M54 to M6 Link Road TR010054

Environmental Statement Addendum: Proposed Scheme Changes October 2020

**Environmental Statement Addendum: Proposed Scheme Changes
October 2020**

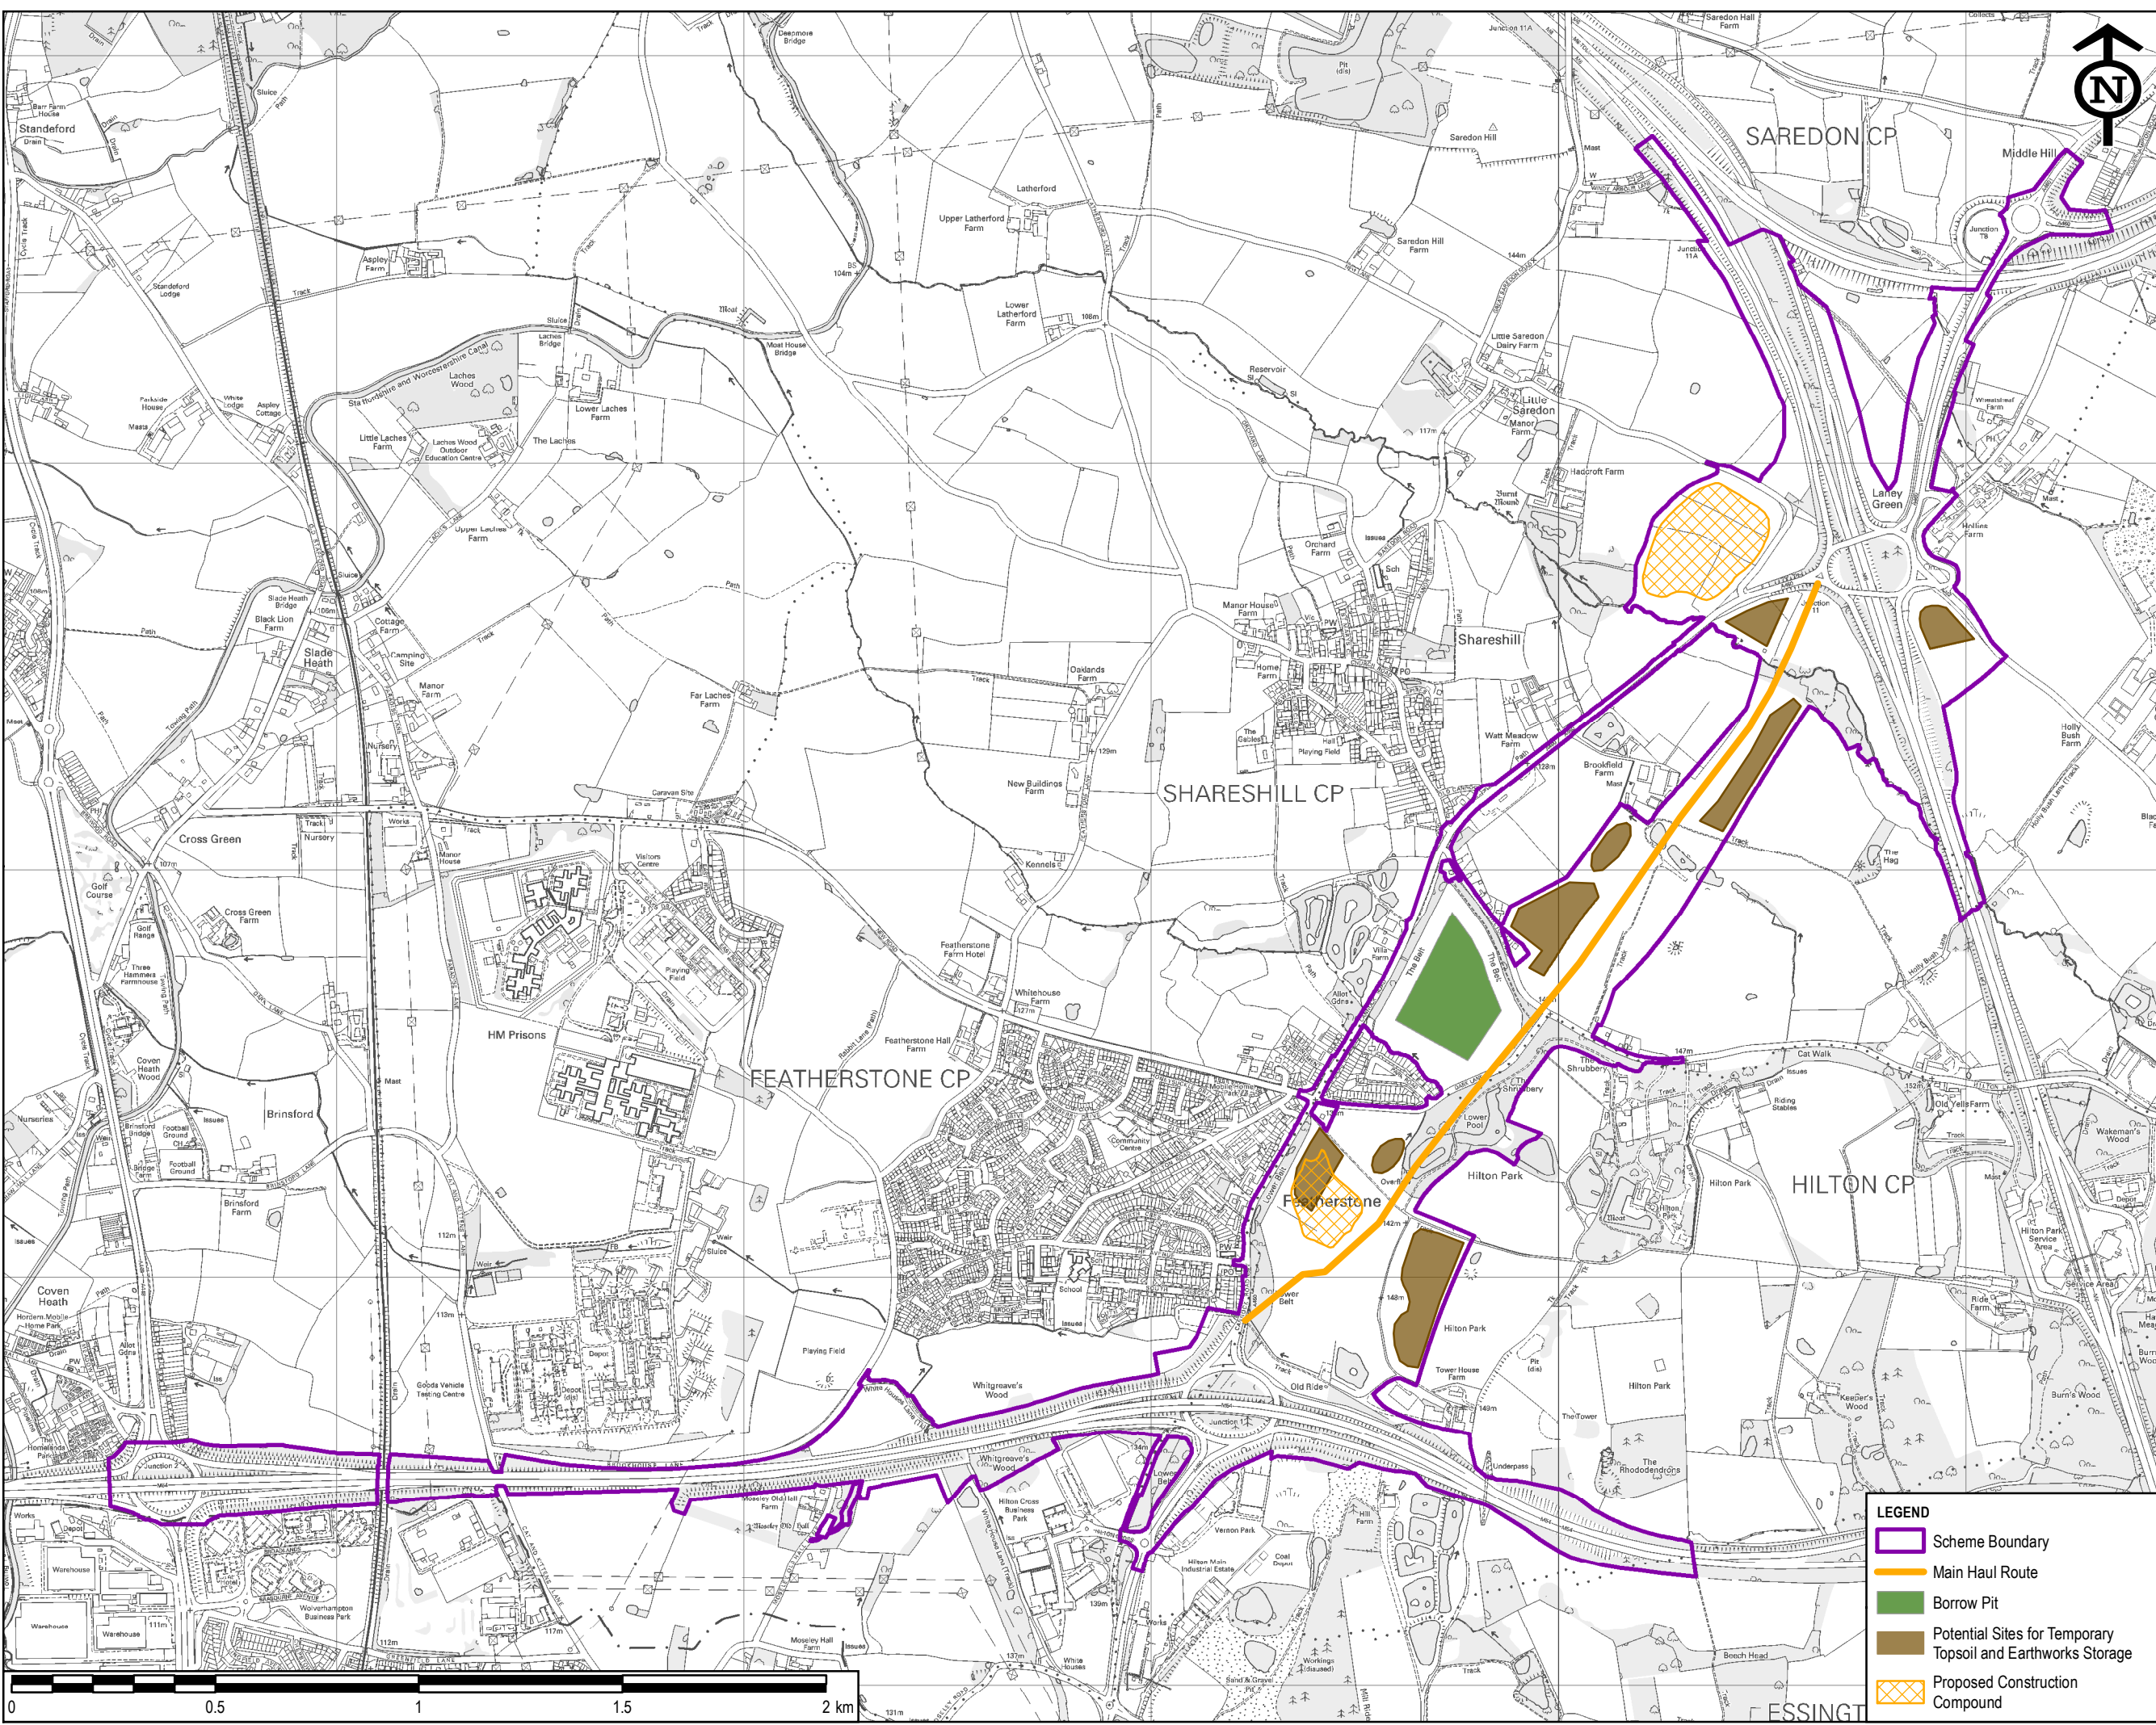
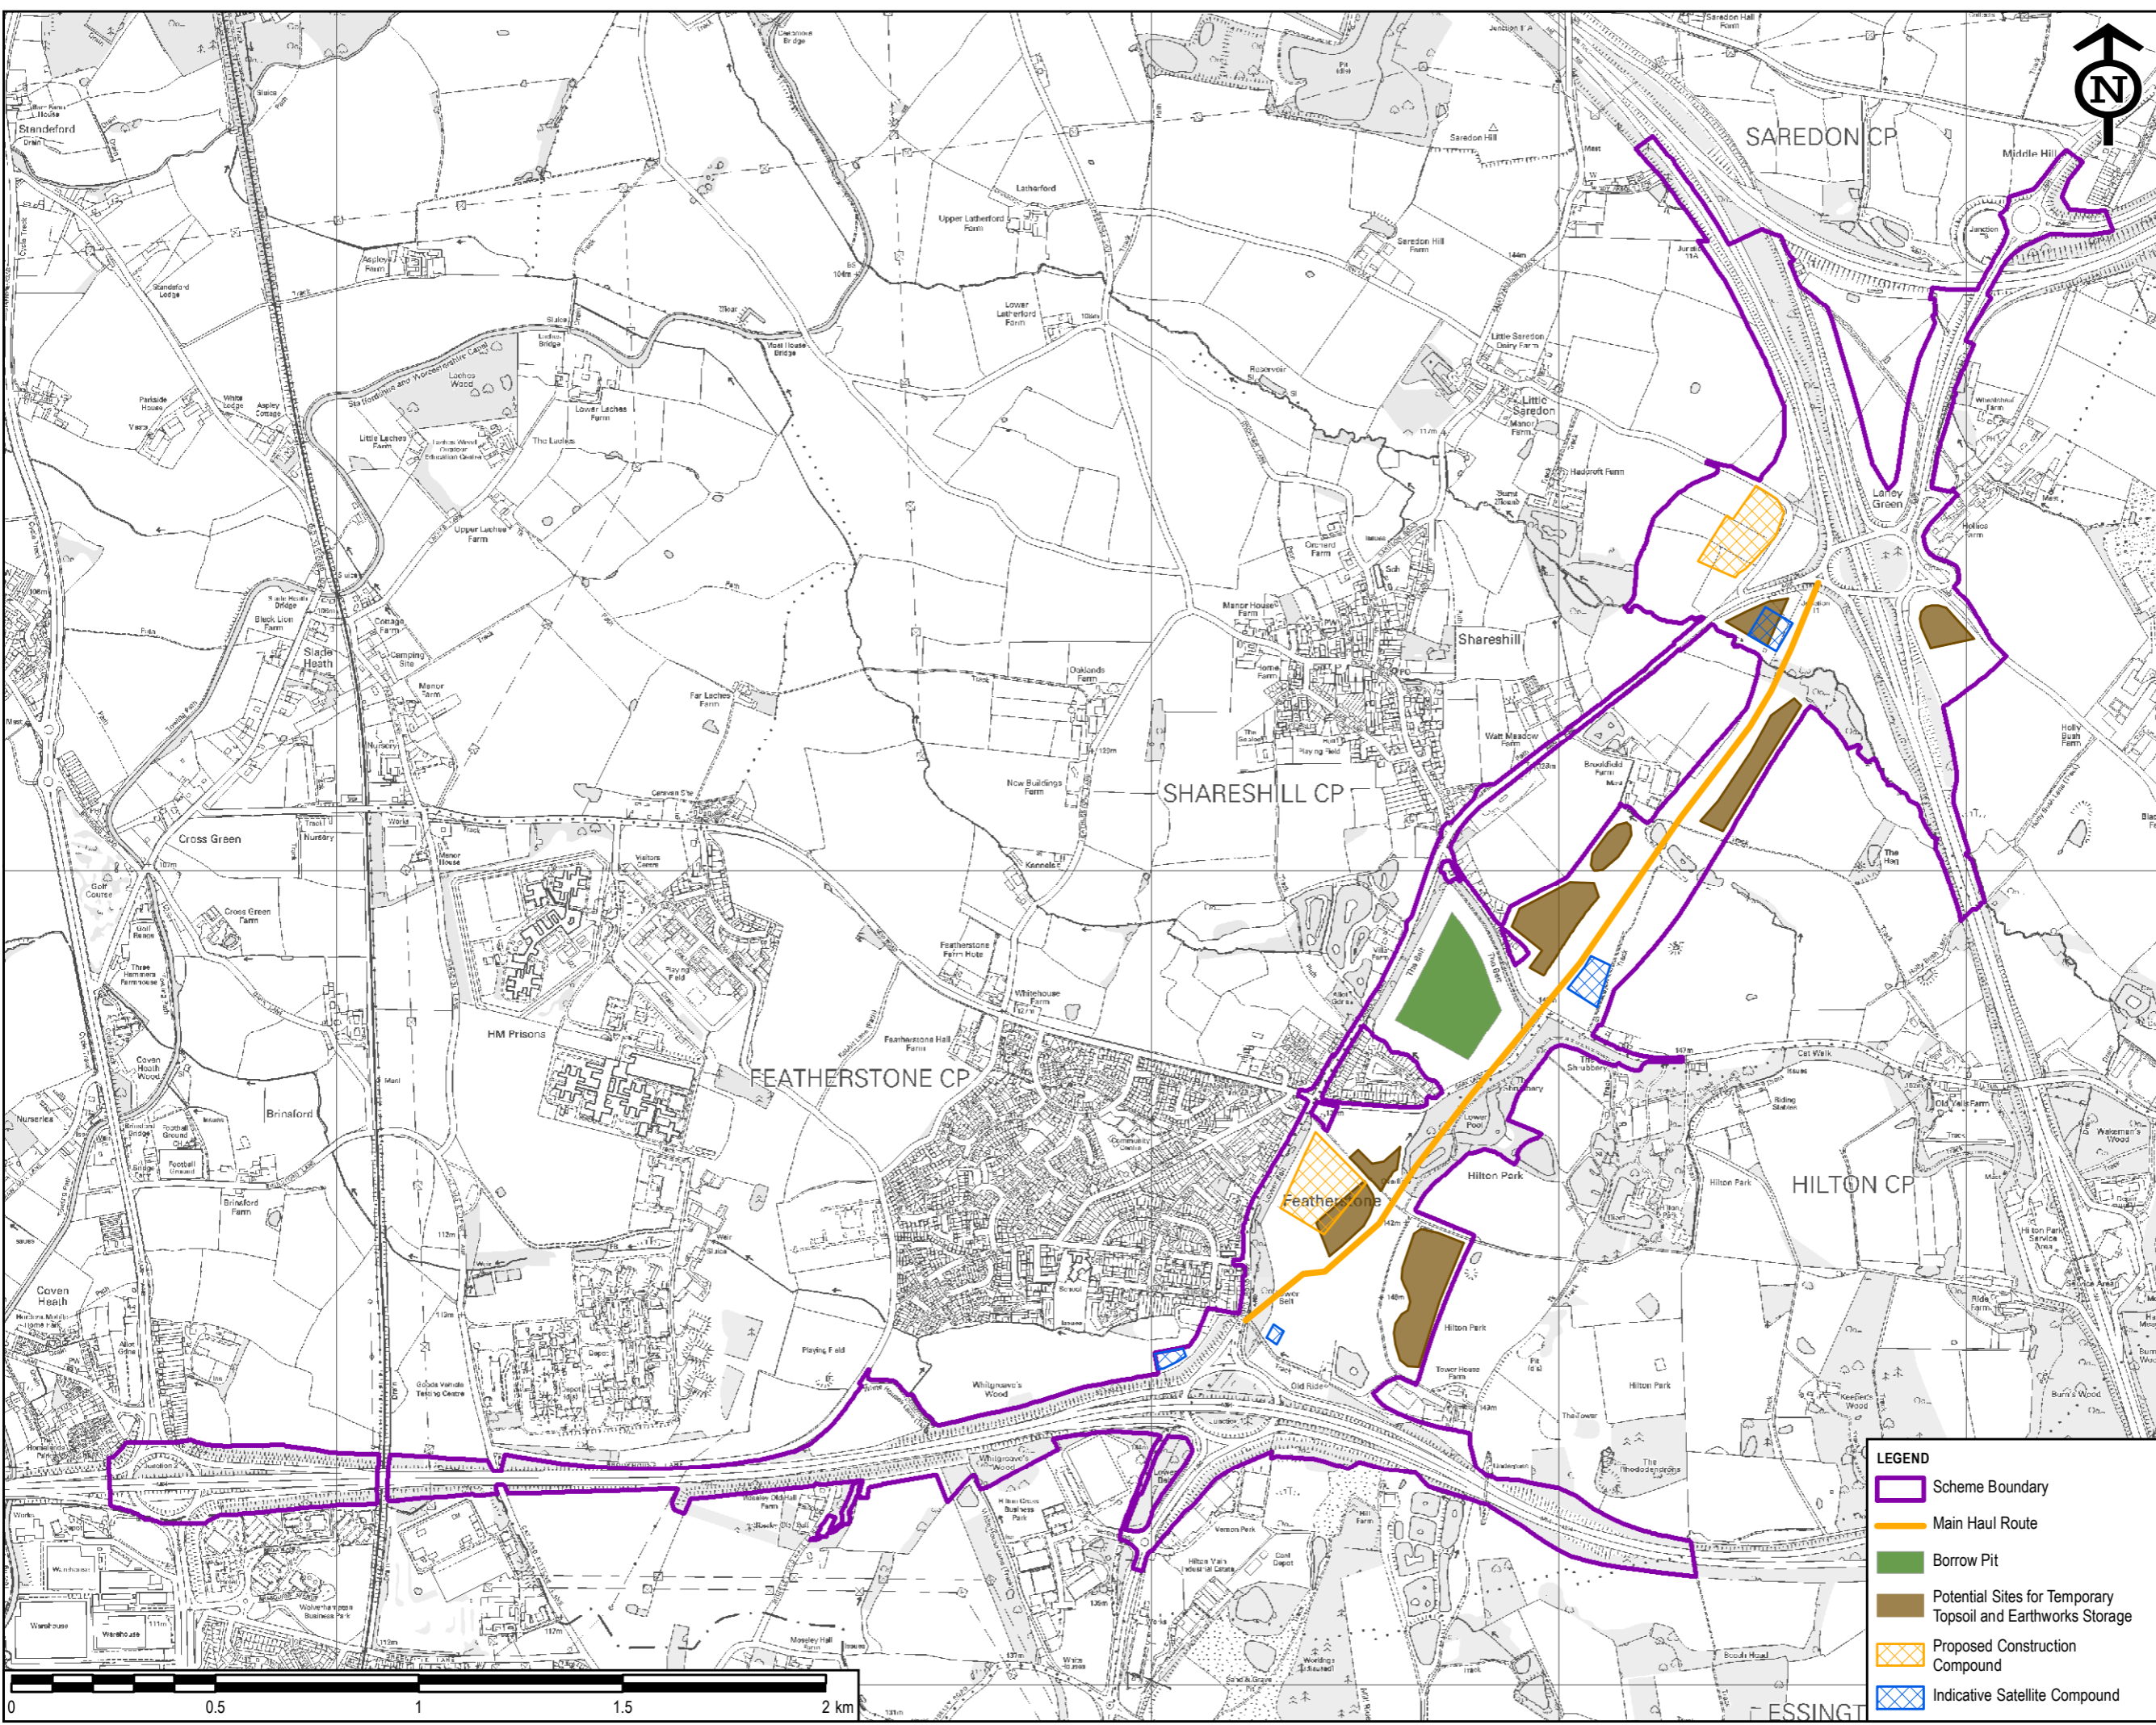
- 2.1.4. Alterations to Figure 2.9: Construction works [APP-065/6.2], including the addition of satellite compounds and minor alterations to soil storage areas have also been considered as part of the assessment of design changes. Where soil storage areas were partly located in an area no longer required permanently for environmental mitigation, the storage areas have been adjusted, where appropriate, to allow this land to remain with the landowner during construction and operation of the Scheme. Figure 2.9 of the ES has been revised and a new version (Version 2) submitted to the Examining Authority with this Note.
